Building Inspections - 880 Forest Ave., 20 bathrooms at Deering Pavilion

From: Jeanie Bourke
To: buildinginspections@portlandmaine.gov
Date: 11/20/2015 12:40 PM
Subject: 880 Forest Ave., 20 bathrooms at Deering Pavilion

From: Alan Hinkley (DICON)
Sent: Tuesday, November 03, 2015 4:19 PM
To: 'Jeanie Bourke' <JMB@portlandmaine.gov>
Subject: 20 bathrooms at Deering Pavilion

A1.2

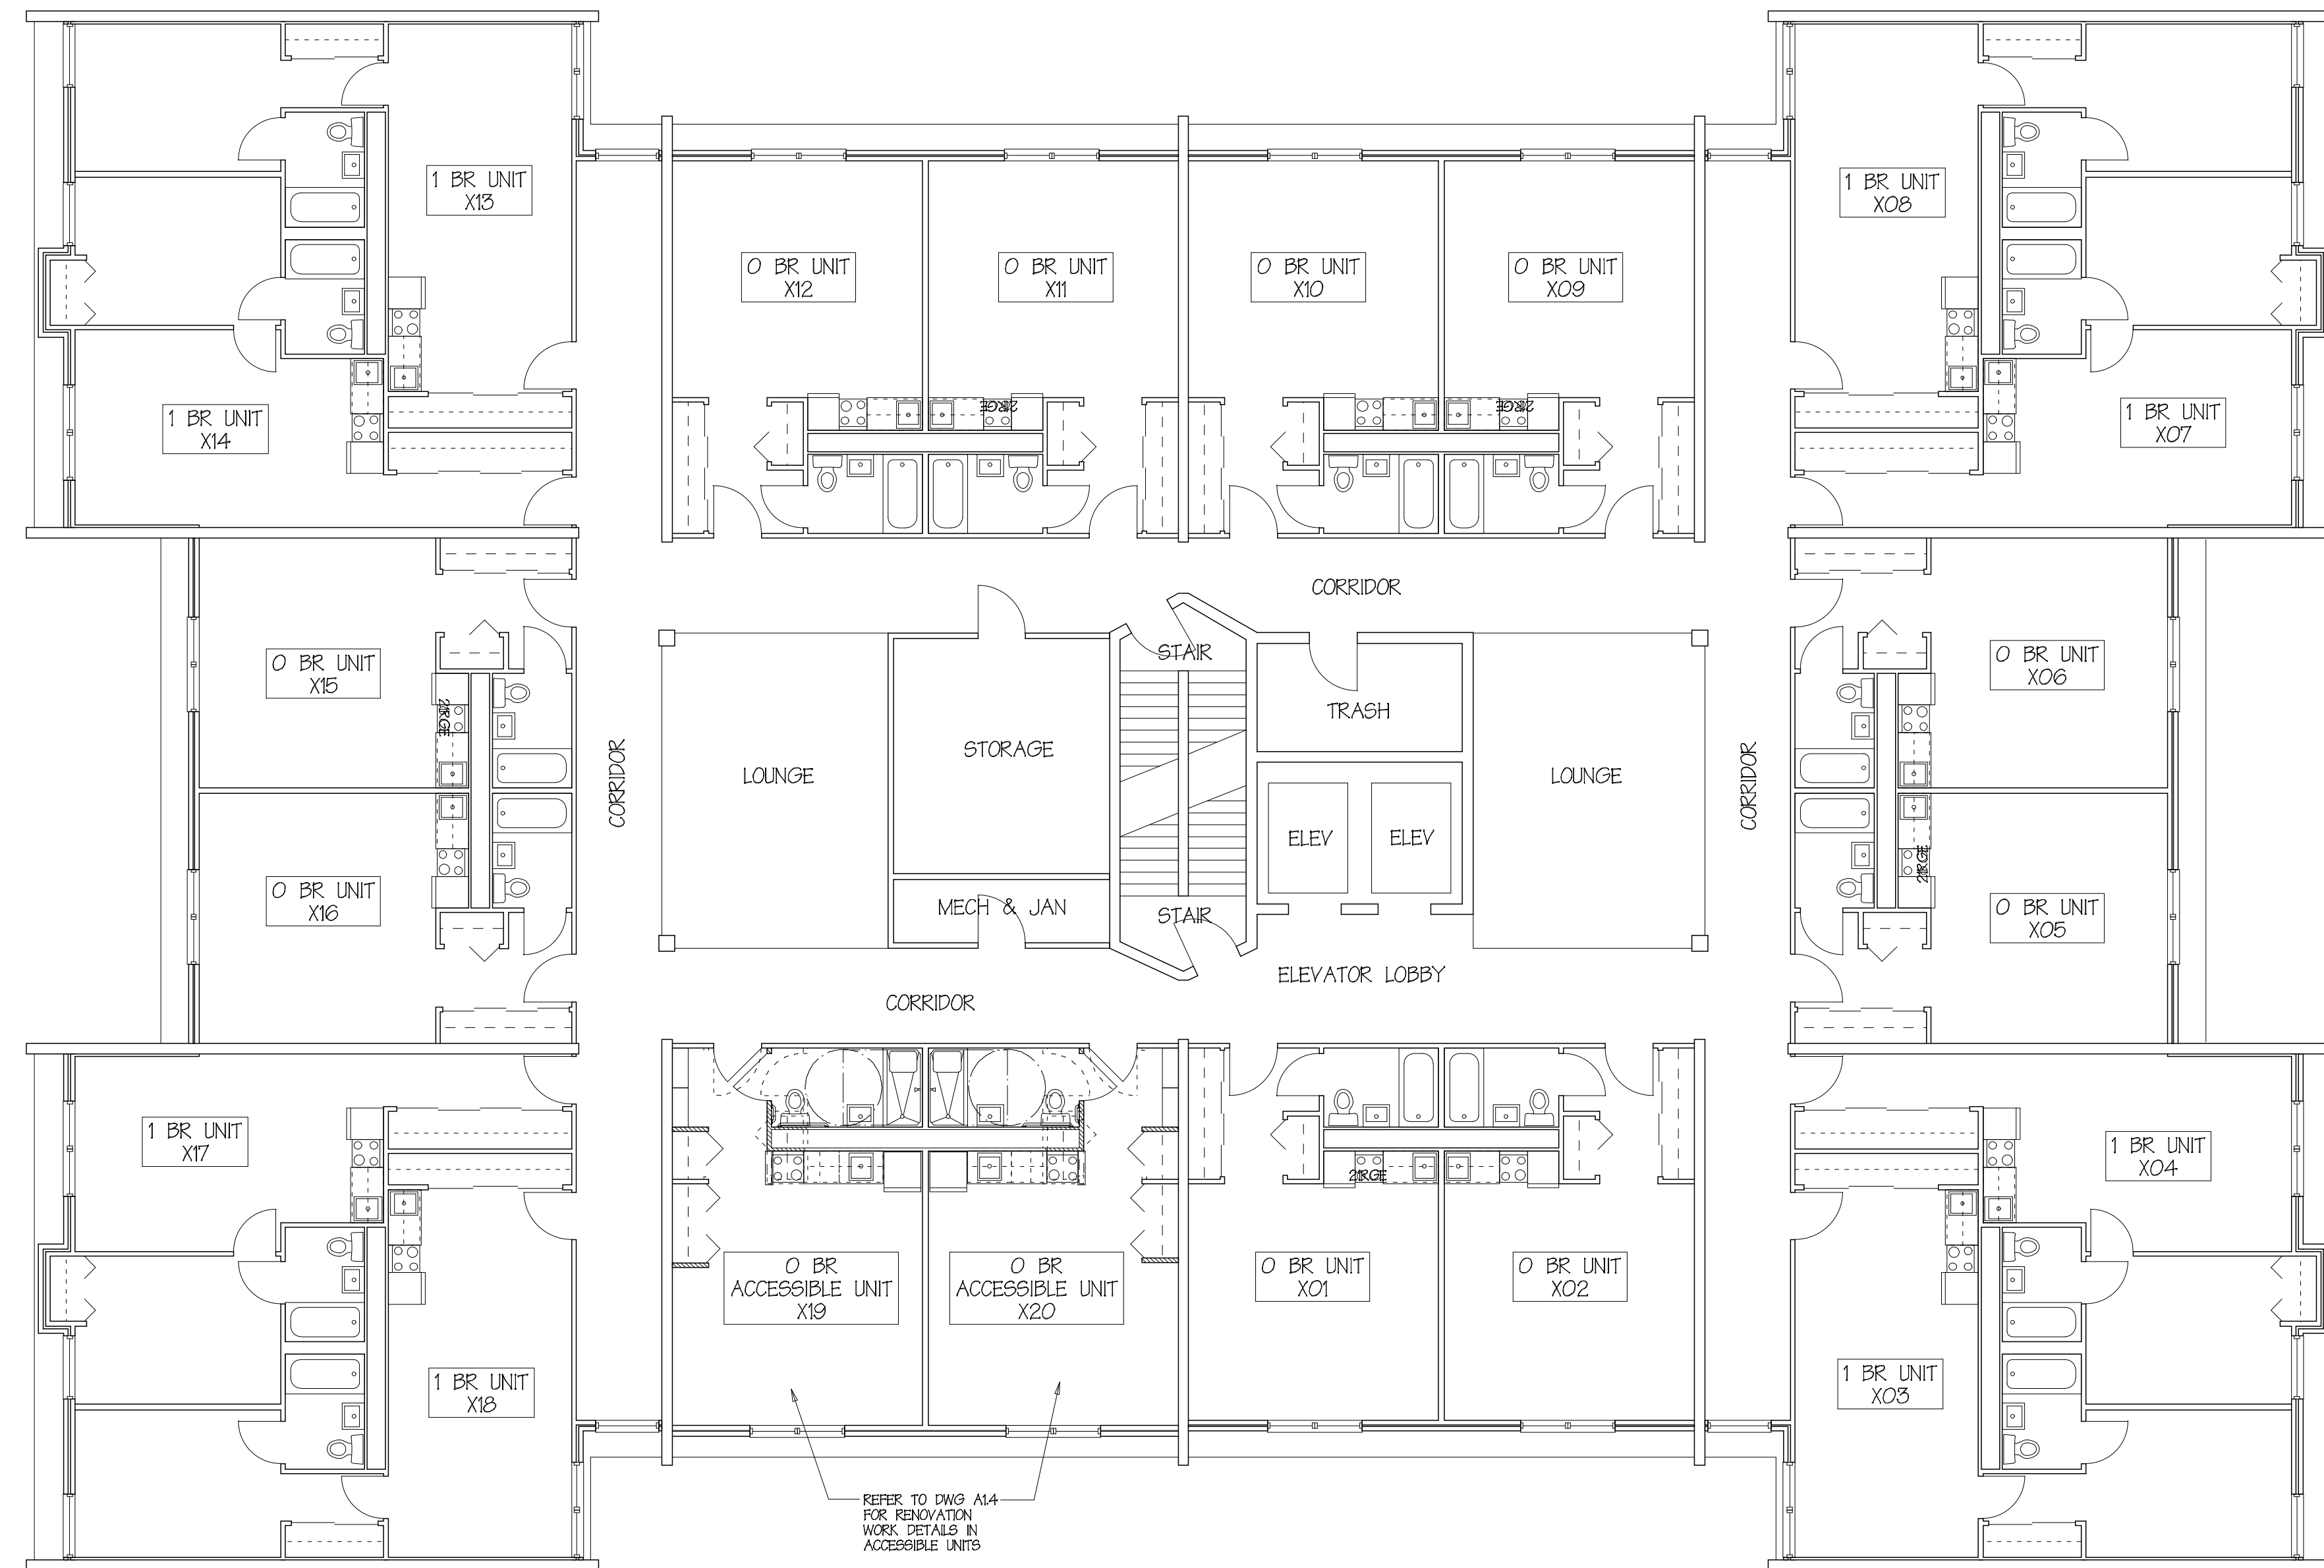
1. The application needs to be completely filled out, exempt are the 3 design sheets.
2. Indicate on the typical floor plan which bathrooms are being updated.
3. The pdf file 2015000010144 has 3 plans that need to be filed as separate pdfs. Please use a description for each plan file for what the information is.
4. The Fast Track pdf should be named as such.

The A-1-2 Typical floor. All floors 2 thru 11 are the same lay out also the same #. The units that we are doing at this time are unit's #5 and #6 on every floor. This will allow us to change out the drain lines. Please feel free to contact me with any questions that you may have.
